16/11/2021

St Luke's Grammar School - Senior School Campus and Sports Centre (SSD-10291)
Request for additional information

The Department has received comment from Transport for NSW (TfNSW) on the Response to Submissions Report for the above application, SSD-10291.

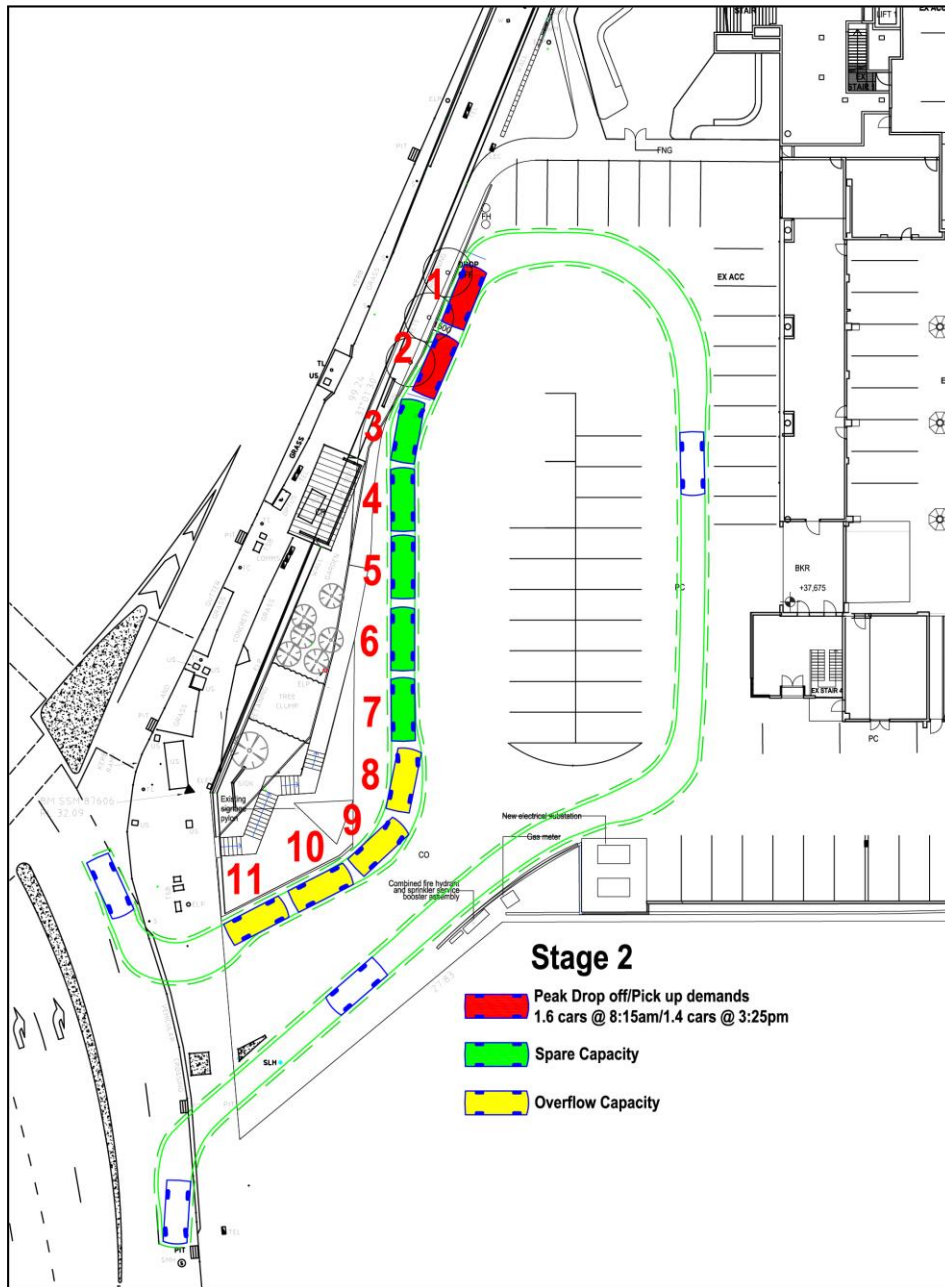
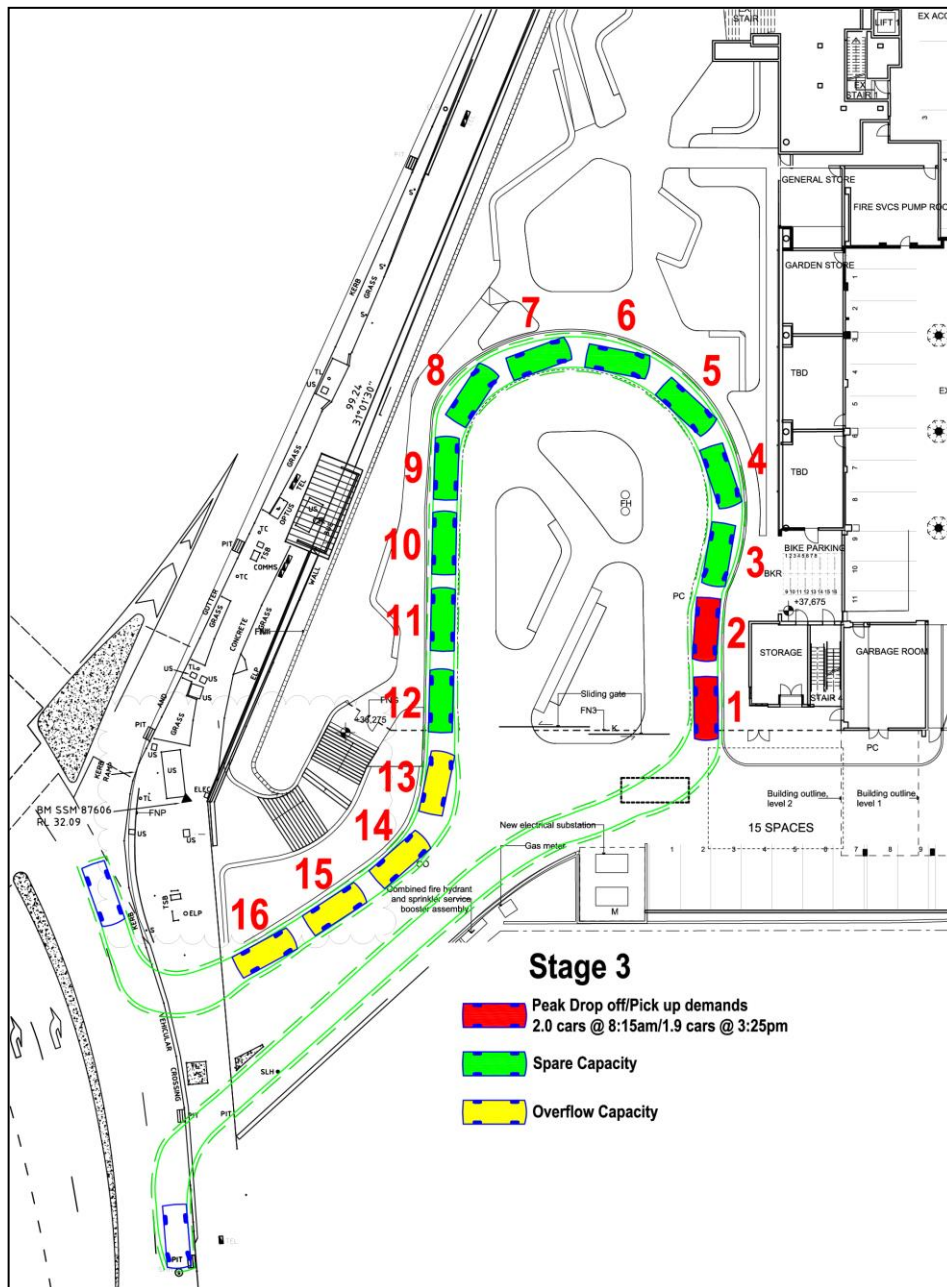
The Department notes that TfNSW have raised significant concerns regarding the existing driveway location and the resultant safety issues. Consequently, TfNSW have advised that they do not support the proposal in its current form.

To enable the assessment to progress, the Department strongly encourages you to explore alternate options for driveway access to the site or else consult with TfNSW to resolve this issue.

The Department cannot progress with the assessment, unless the application demonstrates that the driveway can safely operate without compromising the safety of the users and the surrounding road network.
